MODIFICATION REQUEST:

61 Mobbs Lane, Epping (Former Channel 7 Site)

Internal reconfiguration and minor design changes to Buildings 7 and 8 (MP 10_0158 MOD 2)

Director-General's
Environmental Assessment Report
Section 75W of the
Environmental Planning and Assessment Act 1979

PTW
Title Building 8 Elevation EW
Scale 1:100 @ A0
1:100 @ A0

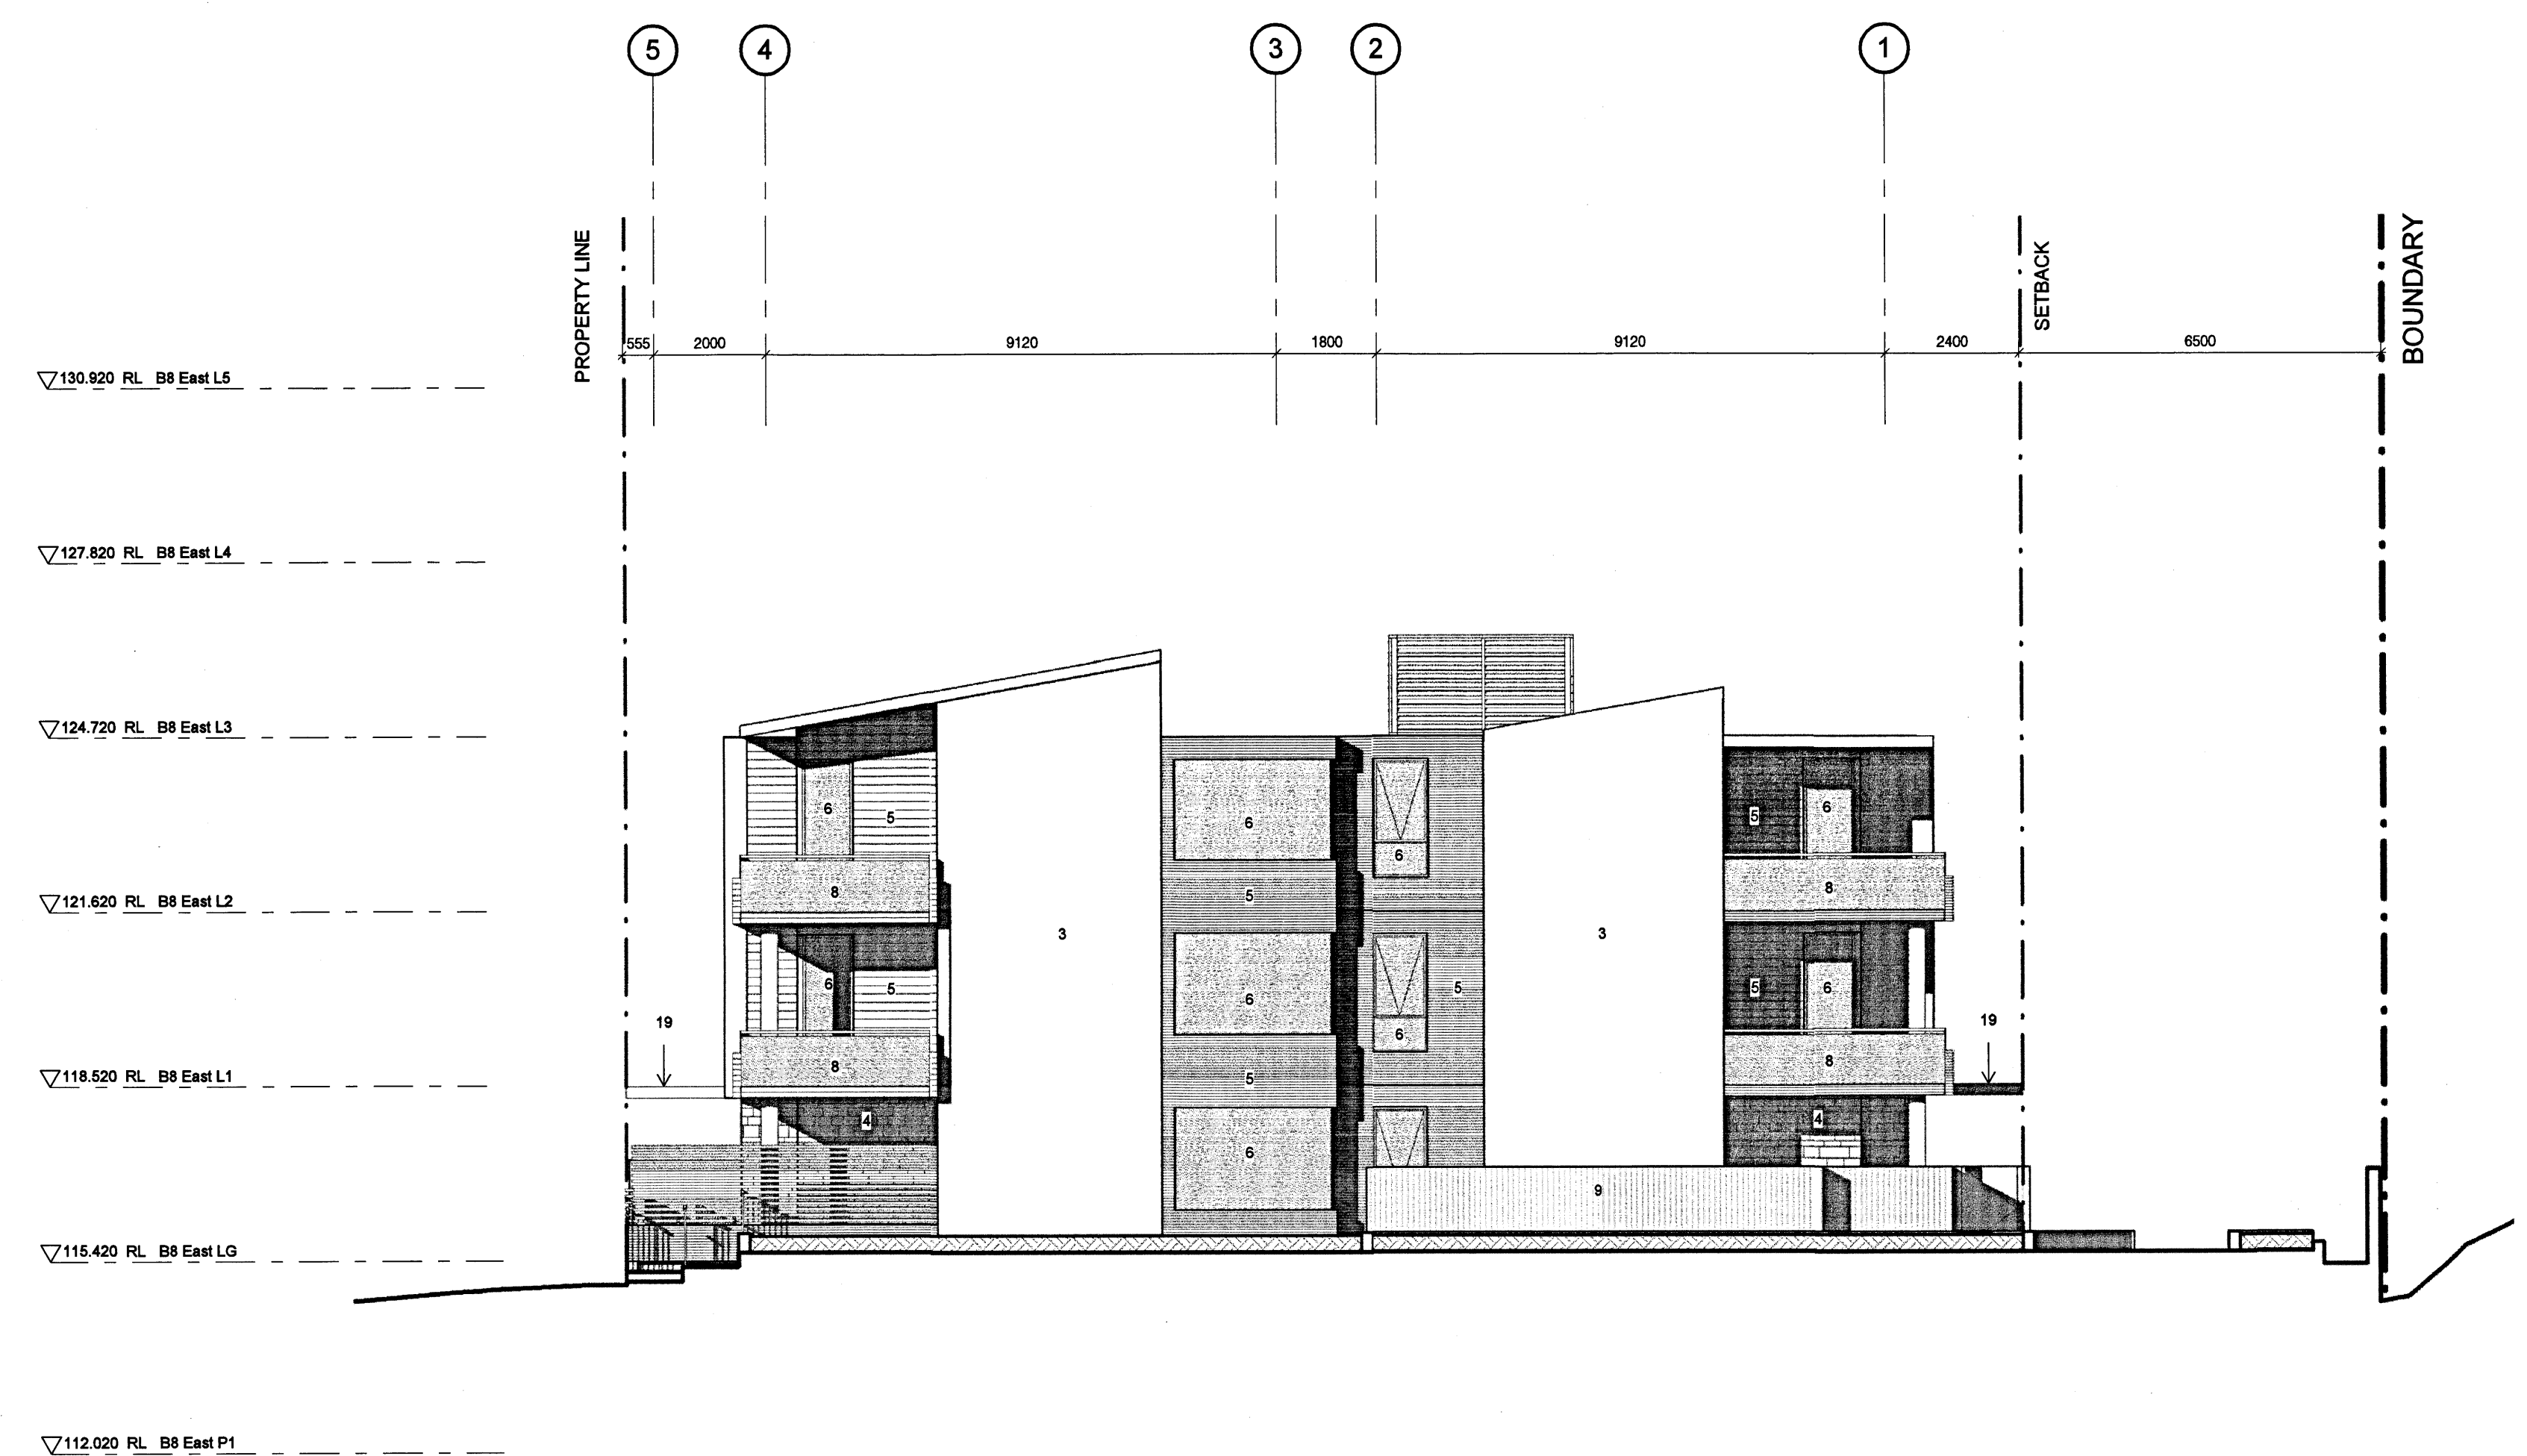
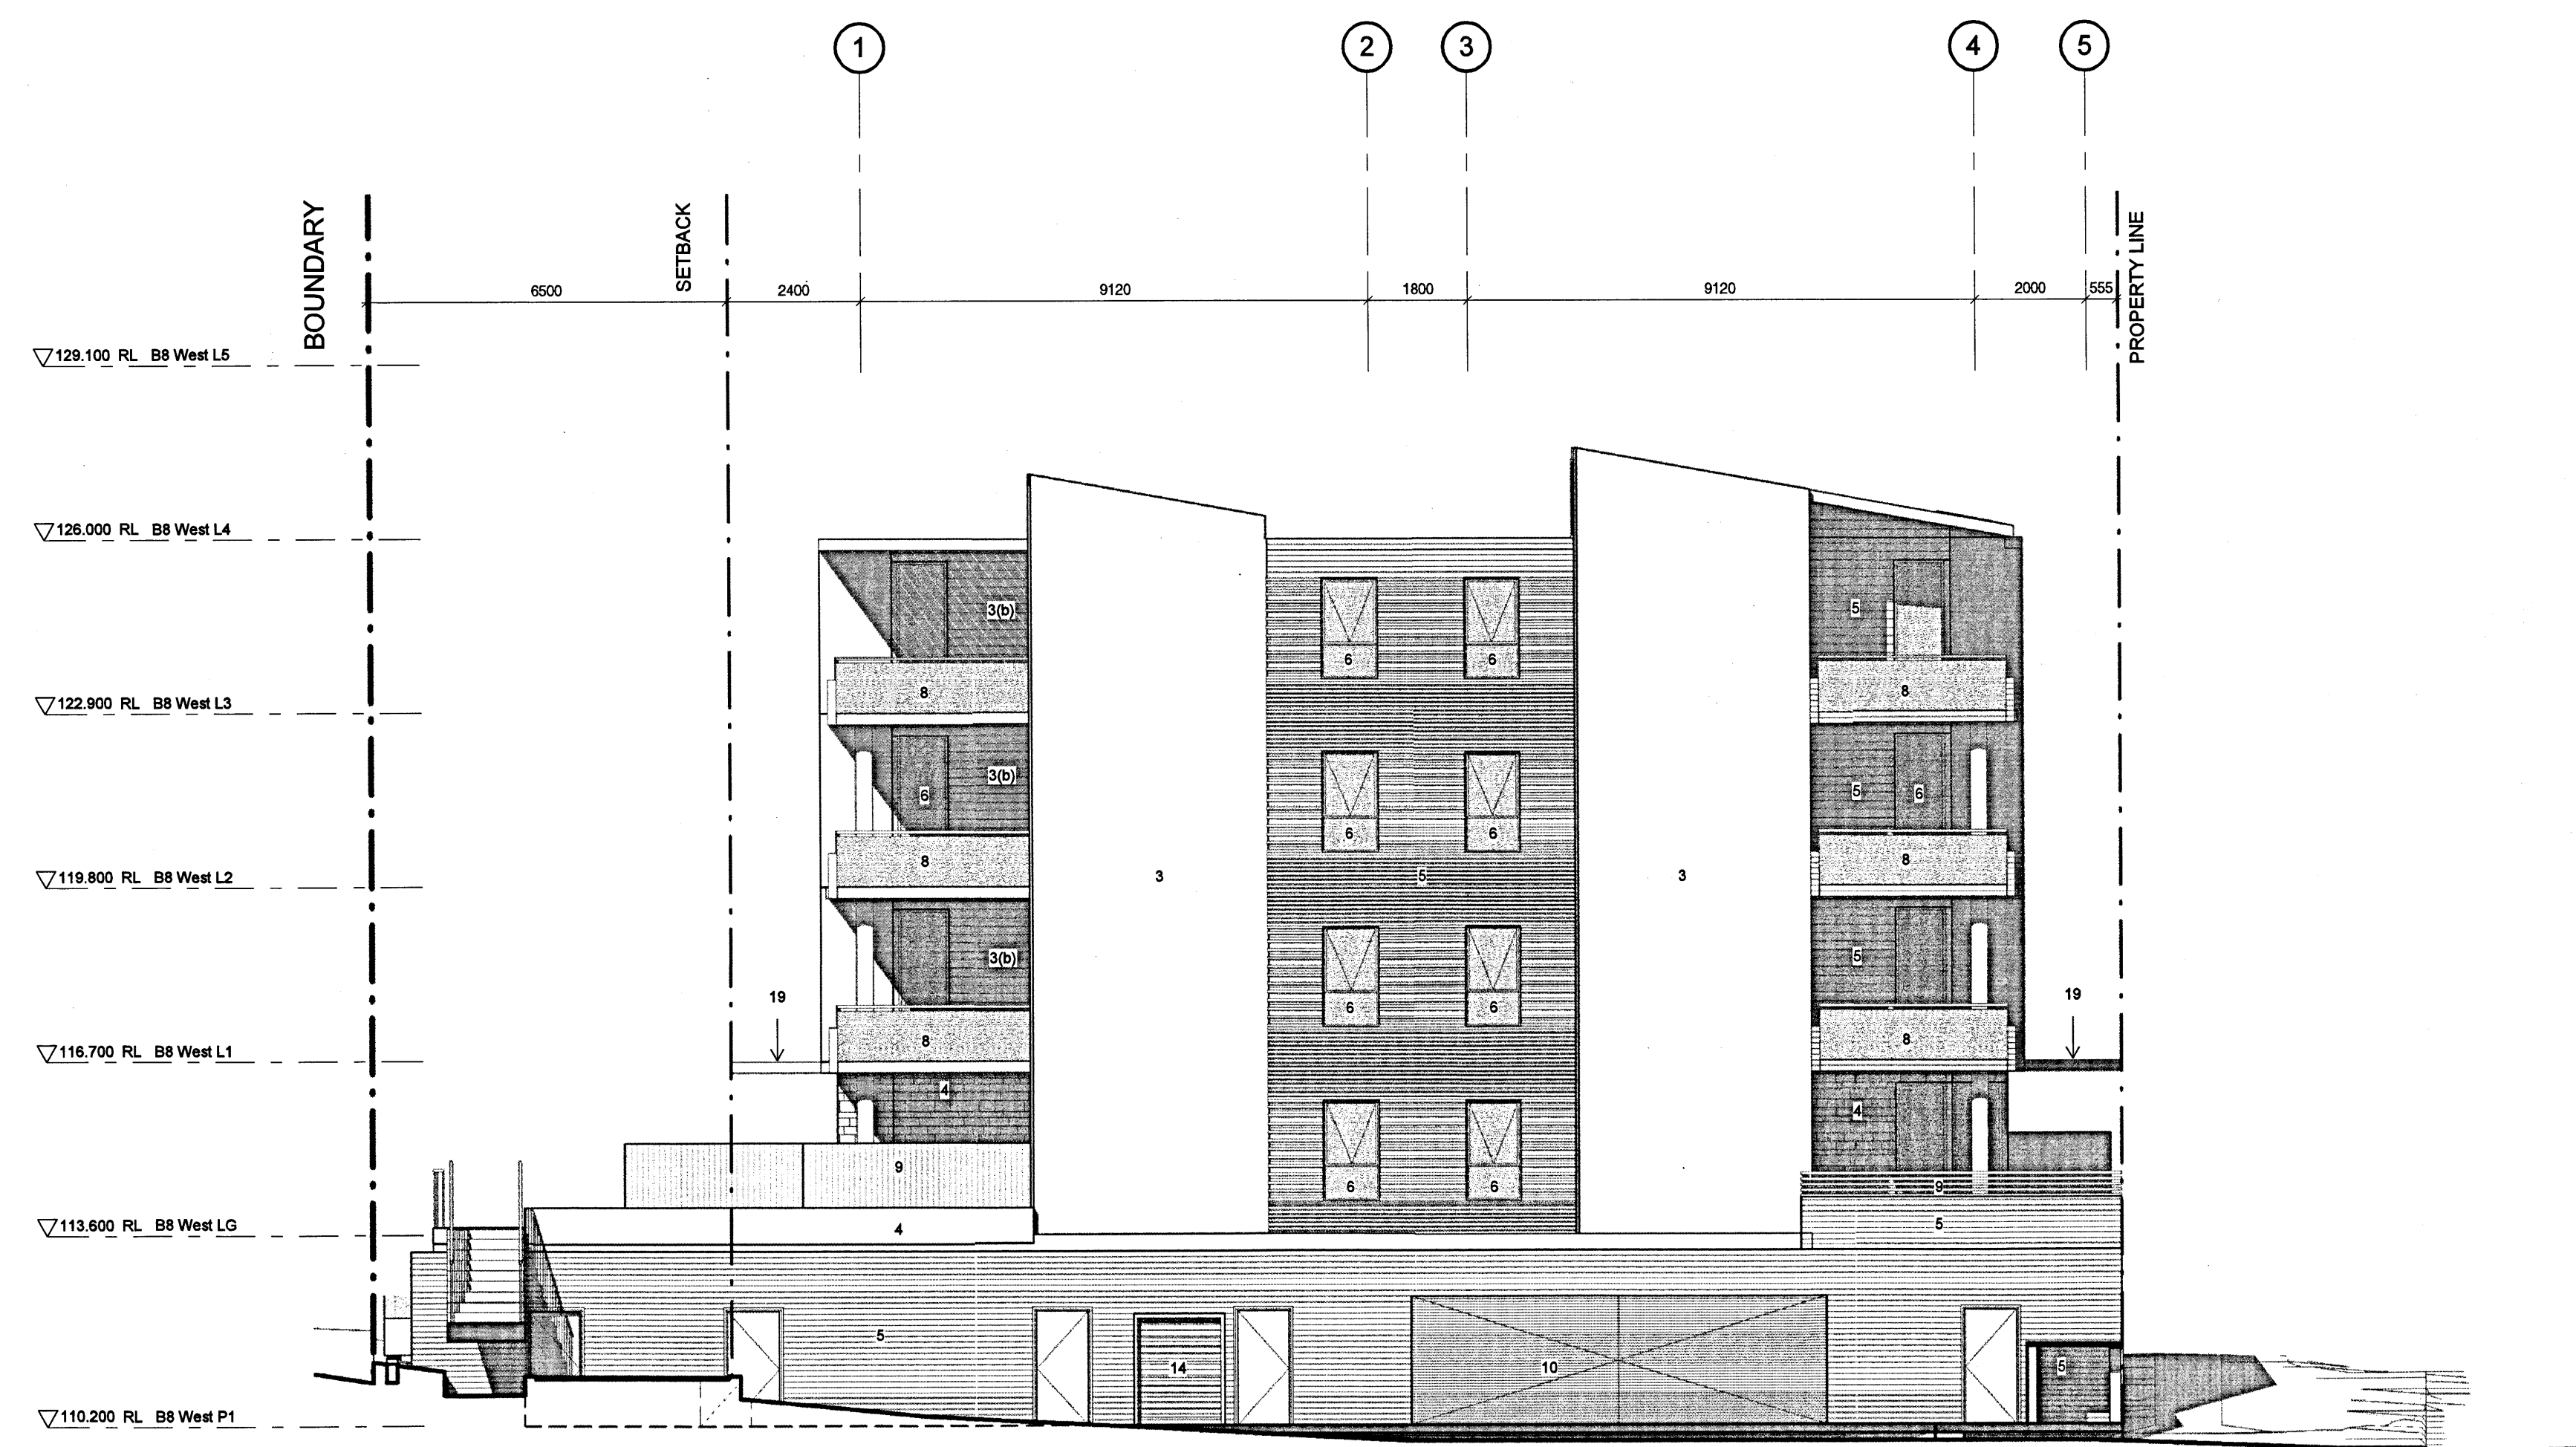
The application seeks approval to alter the location of the car park roller door on the western elevation of building 8. The department notes that the proponent has not sought to alter the corresponding basement plan to reflect this change. The proponent has advised that changes to the corresponding basement plan are not necessary as the proponent's certifier has confirmed that he is satisfied that the proposed modification would not result in any adverse traffic impacts, and as such this aspect of the proposal can be dealt with when he certifies the Construction Certificate drawings. Given the above, the department is satisfied that the proposed relocation of the roller door is acceptable.
